Attn: Thomas Piovesan, Planning Officer  
Re: SSD-70066710, Hudson Vine Mixed Use Redevelopment

Thank you for the opportunity to make a submission on the Hudson Vine Mixed Use Redevelopment State Significant Development 70066710.

Figure 10 Short Section A (with additional notes in orange)

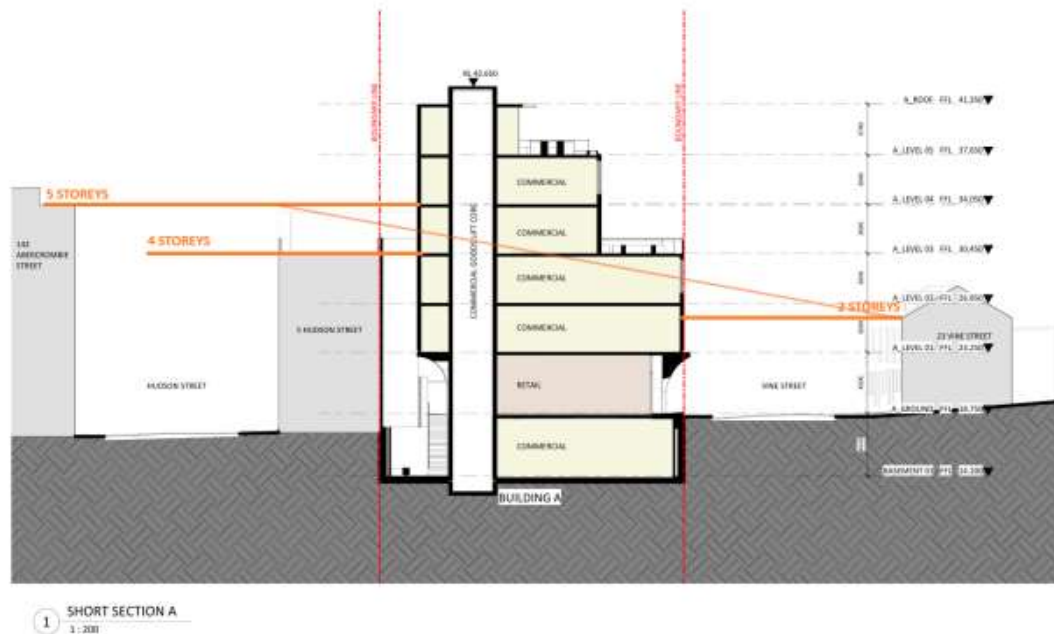
In contrast, the height of the proposed building contradicts the aims of height controls. This can be seen in Short Section A:<sup>44</sup>

Additional notes have been added in orange, highlighting:

- 2 storeys of the proposed building already exceed the height of the 2 storey terraces at 23 Vine Street
- 3 storeys of the proposed building match the height of the 4-storey mixed use building at 5 Hudson Street
- 4 storeys of the proposed building match the height of the 5-storey residential building at 142 Abercrombie Street
- A building with a responsive design should follow the diagonal line from 5 storeys to 2 storeys

Considering the scale of the surrounding buildings, the proposed building matches the size of a 7-storey development. In contrast to *Figure 8 ADG height controls example*, the proposed building exceeds the height of the immediately adjacent building (5 Hudson St), plus both buildings on the other sides of the road (23 Vine Street and 142 Abercrombie Street). Due to most of the surrounding buildings falling within the Darlington Heritage Conservation Area, it is unlikely that their height will change.<sup>45</sup>

It cannot be found that the proposed building meets the aims of height controls provided by the ADG, given how much higher each storey is compared to the surrounding buildings. A compliant 5 storey building should be similar in height to 142 Abercrombie Street, yet this proposed building is 7.3 metres taller than that 5-storey building.

The proposal should be refused or amended to ensure that:

- The height, bulk and scale are consistent with impacts reasonably expected for 5 and 3 storey building heights e.g. by lowering the height to 15 metres
- The form and massing respond and provides transition between scales as per the urban design principles of BEP1 e.g. by adding setbacks from 146-158 Abercrombie St and 5 Hudson St
- The aims of the height controls are met under the ADG e.g. by stepping the building down from Hudson St to Vine St, rather than raising the building higher than 142 Abercrombie St.
